**Permit Number: BCOM2602-0003**

Description: **Snack Store Chap Guatc-Mex**

Site Address: **204 E JACKSON BLVD Suite A**

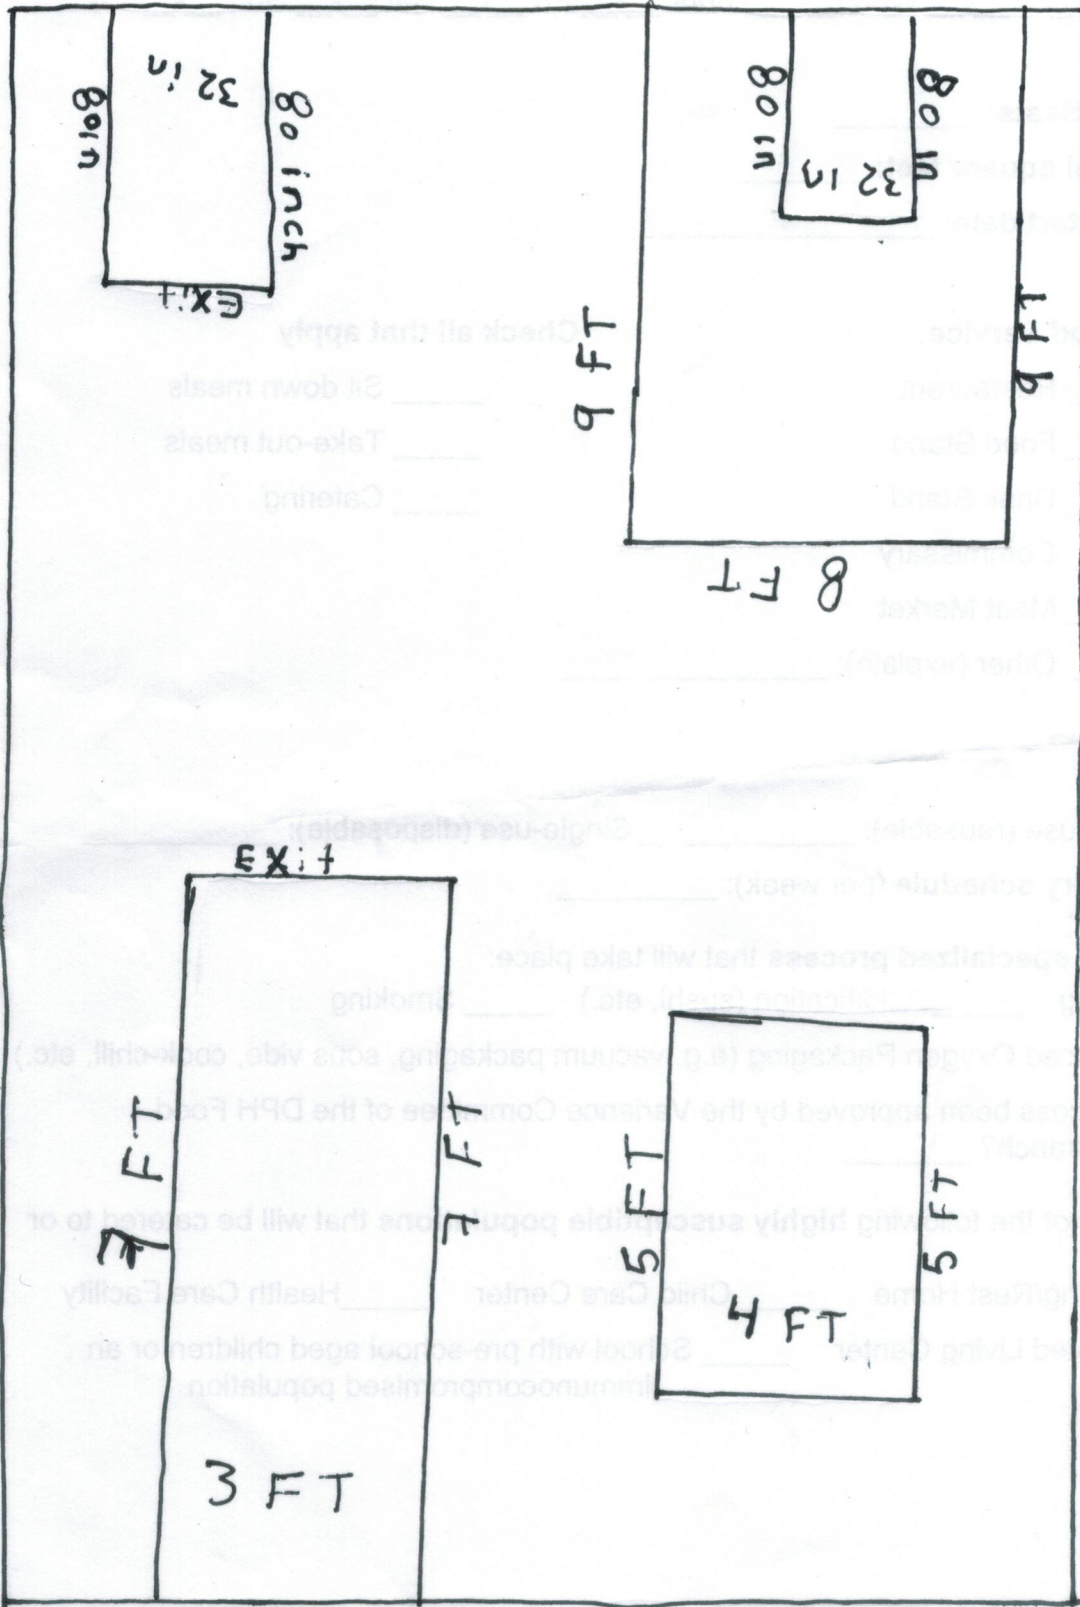
SENT DATE	RETURNED DATE	DUE DATE	TYPE	CONTACT	STATUS	REMARKS
Review Group: 1ST PLAN REVIEW						
2/19/2026	2/23/2026	3/5/2026	PUBLIC UTILITY	Public Works	APPROVED	See Notes
Notes: According to the Land Use Application, there will only be pre-packaged snacks but I wanted to include a review in case you needed to see it. As long as there is no cooking we wouldn't have to do a review. If food was to be prepared at the site a outside grease trap would need to be installed.						
2/19/2026	2/19/2026	3/5/2026	HEALTH AND SANITATION	EH Bucket	NO REVIEW NEEDED	
Notes: According to the Land Use Application, there will only be pre-packaged snacks but I wanted to include a review in case you needed to see it. All foods indicated packaged and ready to sell, no further handling. No review needed.						
2/19/2026	2/26/2026	3/5/2026	FIRE MARSHAL	Roger Sullivan	DISAPPROVED	see notes
Notes: Same comments as the Chief Building Inspector, need a to-scale life safety plan submitted for review.

Review Group: AUTO						
2/19/2026	2/19/2026		COMMERCIAL INTAKE	CP Bucket	APPROVED	
Notes:						
2/19/2026	2/24/2026	3/5/2026	COMMERCIAL BUILDING REVIEW	Brad Sutton	DISAPPROVED	
Notes: This was previously a barber shop according to GIS. Need a floor plan/life safety plan drawn to scale for change of occupancy
